TRAFFIC IMPACT STUDY

Trinity Ranch

- RR-2.5 Rezone

PCD File No. CS252

FIGURE 5

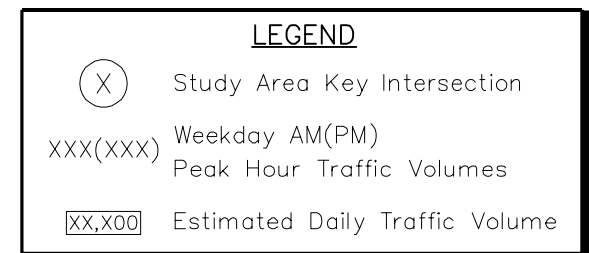
Include this intersection

FIGURE 6

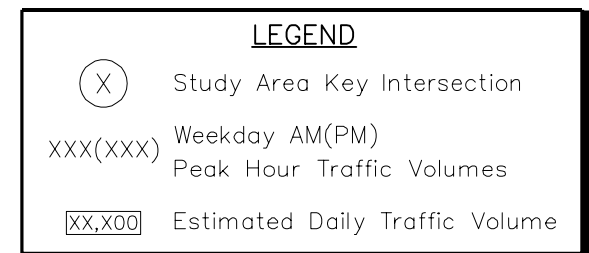
Include this intersection

FIGURE 7

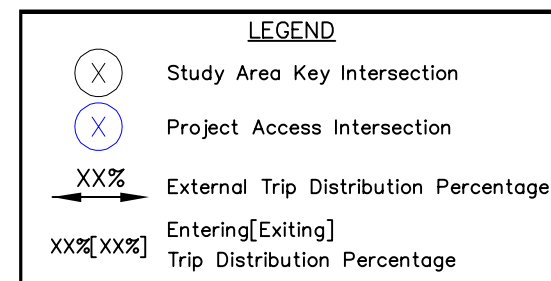
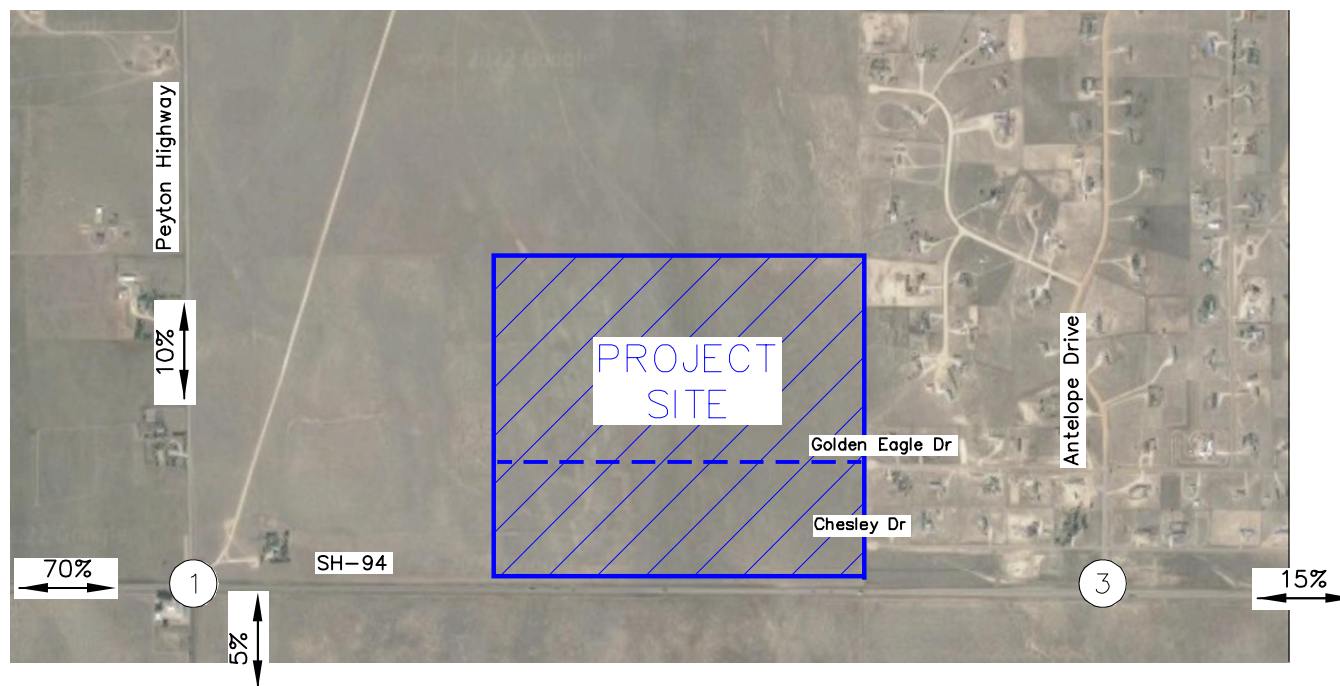
Include this intersection

FIGURE 9

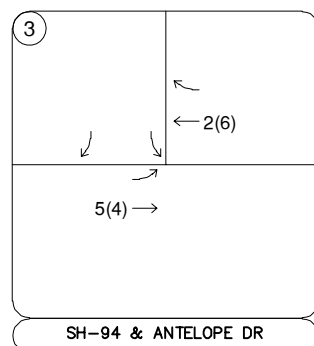
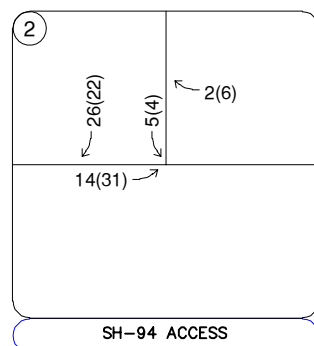
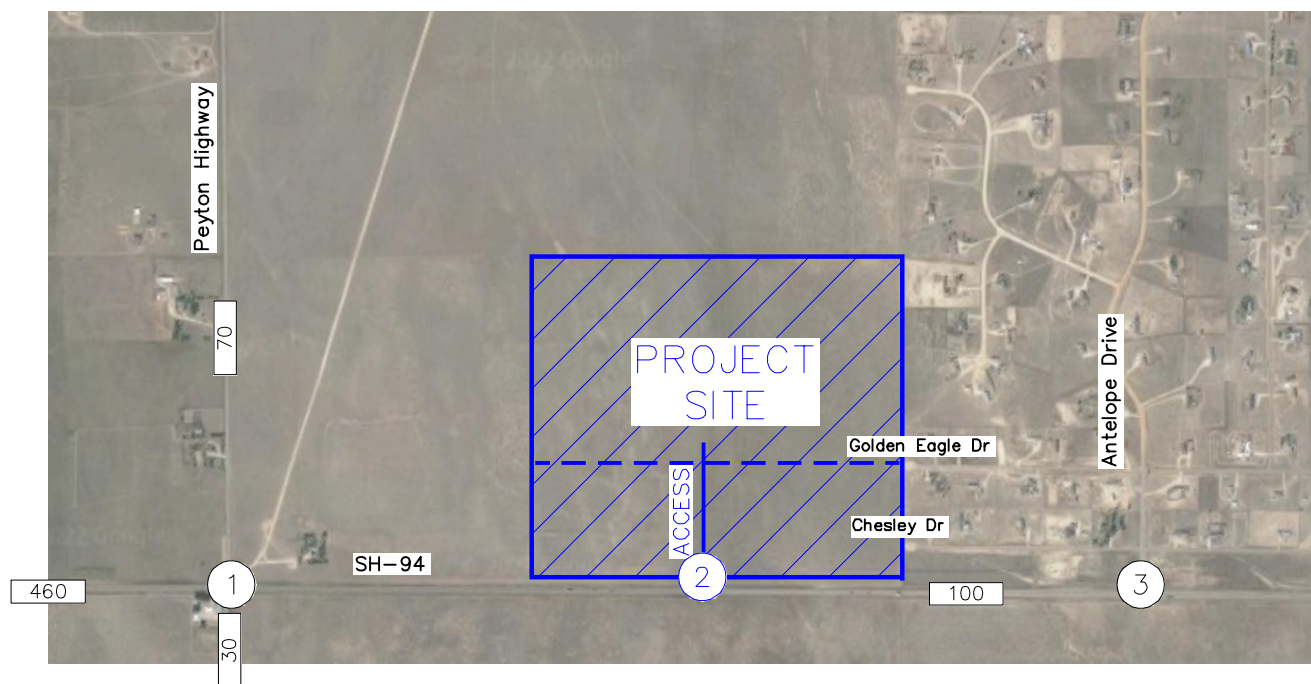
Include this intersection

FIGURE 11

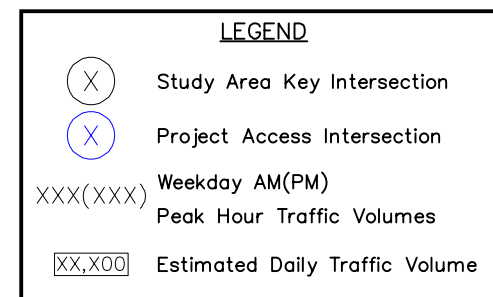
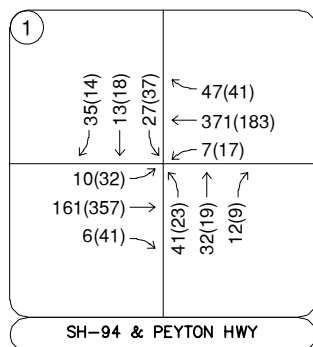
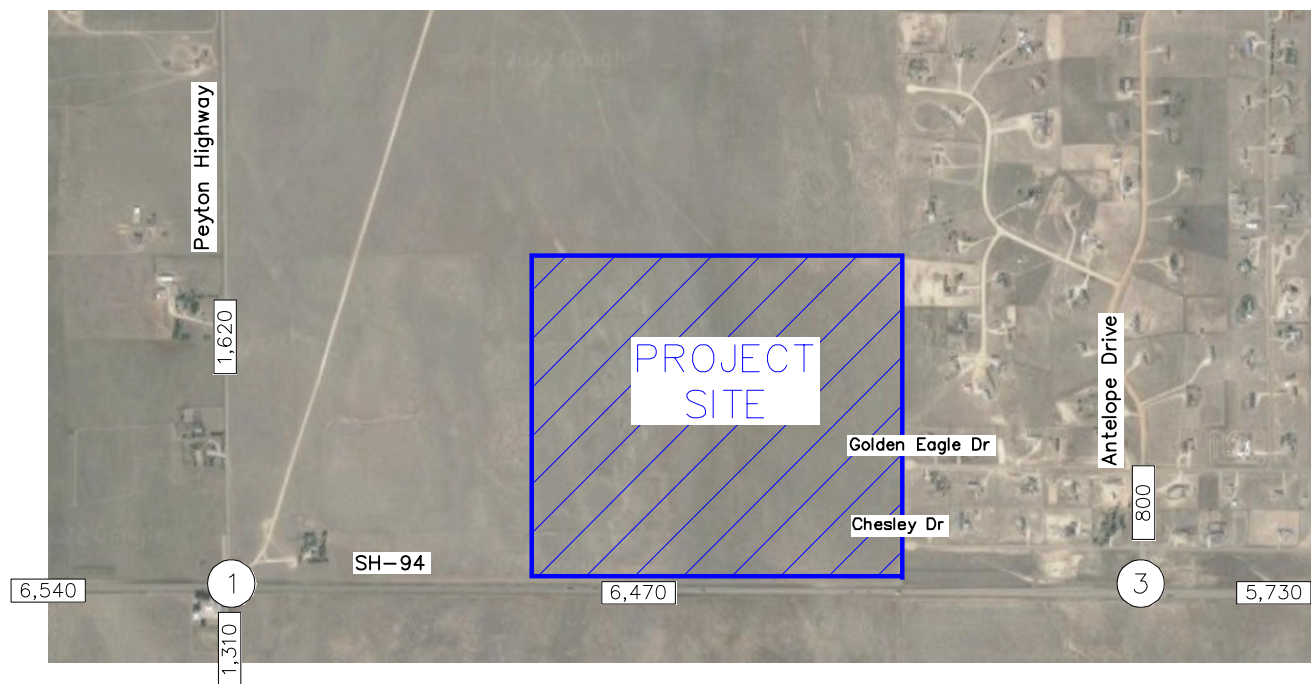
Include this intersection

FIGURE 12

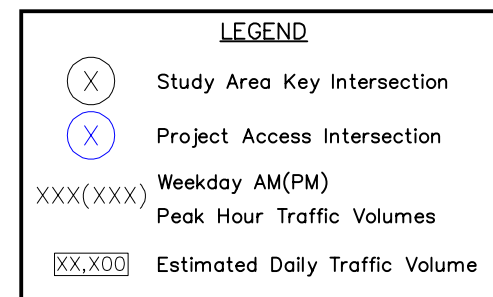
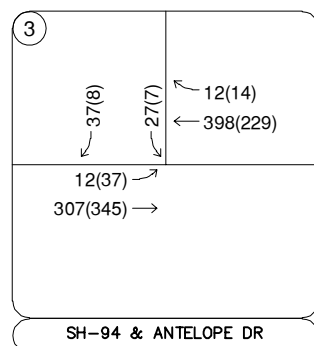
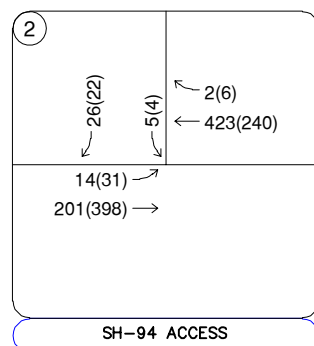
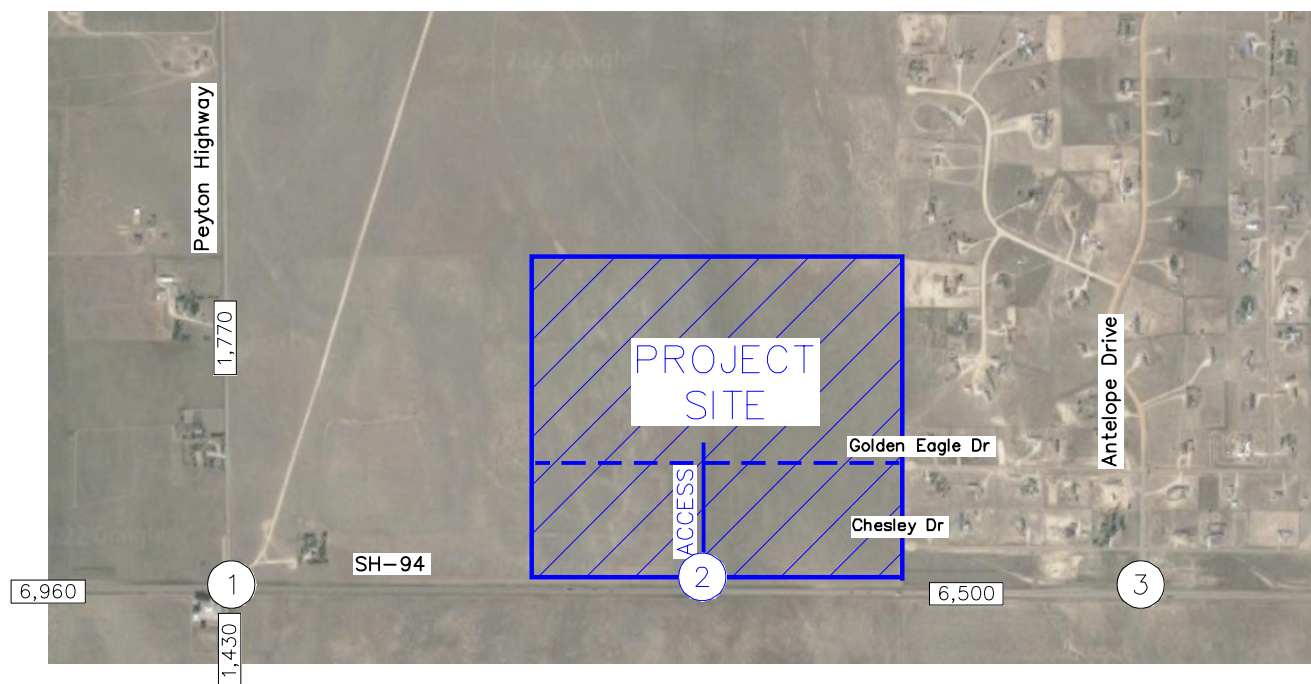
Include this intersection
